Submission No.	37
Organisation Name or Name of Submitter	Caroline Regan and family (26 Dartmouth Road)

Observation Re: Railway (Metrolink-Estuary to Charlemont via Dublin Airport) order 2022 Case Reference Number NA29N.314724

Figure 5-10: Vertical Extent of Works at Dartmouth Road

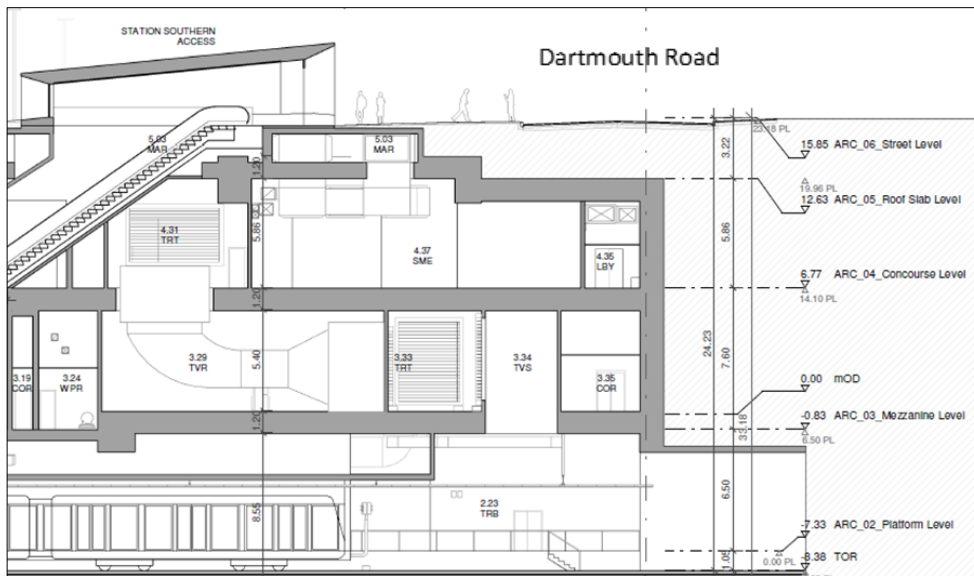
10	B. Structural impact	2	<p>12. The eastern wall of our house is directly at the edge of the proposed terminus' large underground cavity. We draw to your attention the independent expert view from McCabe Durney Barnes, that "it is evident that a very limited assessment of settlement and subsidence has been carried out" in the EIA. This is of utmost concern.</p> <p>13. It is essential that our house is surveyed in detail to determine whether it is at high risk, and to measure settlement and other impacts, before construction. Our home is a protected structure (RPS ref no. 2138).</p>	<p>Your property is separated from the station box excavation by the Green Line structures but is in close proximity to the works - circa 10m.</p> <p>The approach taken by TII for assessing the impact of construction generated ground movements reflects the industry standard three-phased ground movement impact assessment process that is undertaken on tunnelling and underground projects around the world, that includes Channel Tunnel Rail Link (CTRL), Dublin Port Tunnel, Crossrail and High Speed 2.</p> <p>EIA Appendix A 5.17 Building Damage Report, covers the assessed impacts of construction generated ground movements and settlement and includes for the impact on 26 Dartmouth Road which crosses the 10mm settlement contour. EIA Appendix 5.17 refers. The Phase 2 assessment of the ground movement impact to this building is "slight" (an explanation for which can be found in Table 4-4), please refer building B151 (34 Dartmouth Road) in table 5-2 of that appendix. Please note that the assessed building is closer to the excavation than your property and therefore subject to greater settlement impacts.</p> <p>Your property has been designated as "special", and hence a further Stage 3 refined assessment, despite the impact only being assessed as 'slight', will be undertaken that will take account of final design and construction methodology details most likely utilising advanced numerical modelling techniques and further surveys of the building. The results of this refined assessment typically show that earlier assessments are conservative and overestimate the likely impact of construction generated ground movements.</p> <p>Monitoring instrumentation will also be installed in the area to monitor the performance of the works and potential environmental impacts, including those discussed above to ensure that acceptable limits are not breached. TII would also draw attention to the fact that private properties within 50m of the station excavation, or 30m of the tunnel are eligible to subscribe to the Property Owners Protection Scheme (POPs) which includes for pre and post-construction condition surveys and repair of damage up to a value of €45,000. Details of the mitigation measures proposed for property owners can be found in Chapter 11 (Population and Land Use), section 11.6.1.</p>

Figure 1: Process for determining eligibility for Noise Insulation Mitigation or Temporary Rehousing Mitigation

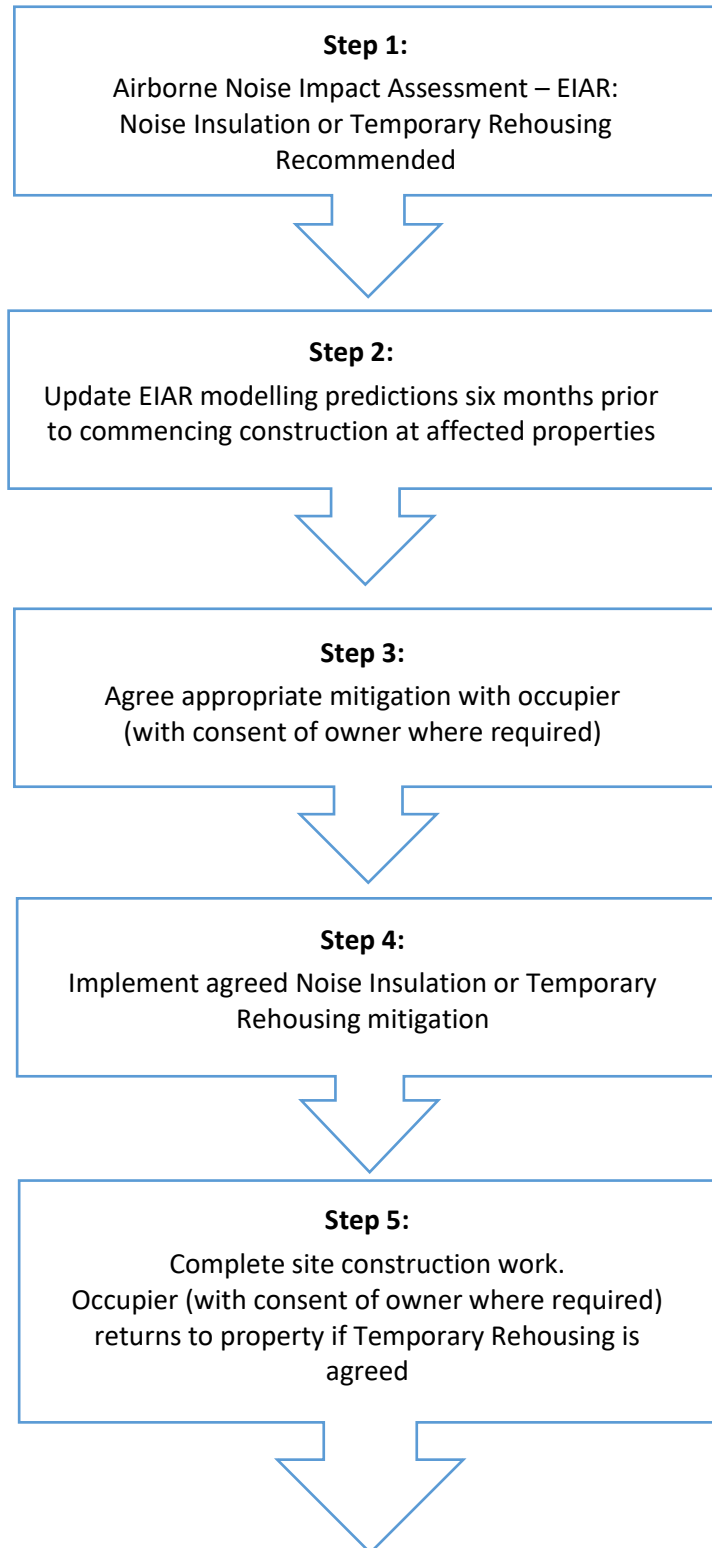
6	A. Health	2	8. The NTA/TII's proposed mitigation measures include "potential temporary relocation". It is not explained what this means, nor what the duration or our family's displacement from our home may be. It is not clear whether there is provision for retrofitting our home with sound insulation.	<p>As noted by responses (3) and (4) above, including allowing for any necessary mitigation measures, noise and vibration levels at 26 Dartmouth Road will not be significant with the exception of TBM groundborne noise for a short temporary duration of approximately 2 weeks. Therefore it is considered relocation will not be necessary. Following mitigation measures the airborne construction noise levels at 26 Dartmouth Road will be below the threshold value of 70 dB and as such mitigation in the form of noise insulation to the windows of this property will not be required.</p>
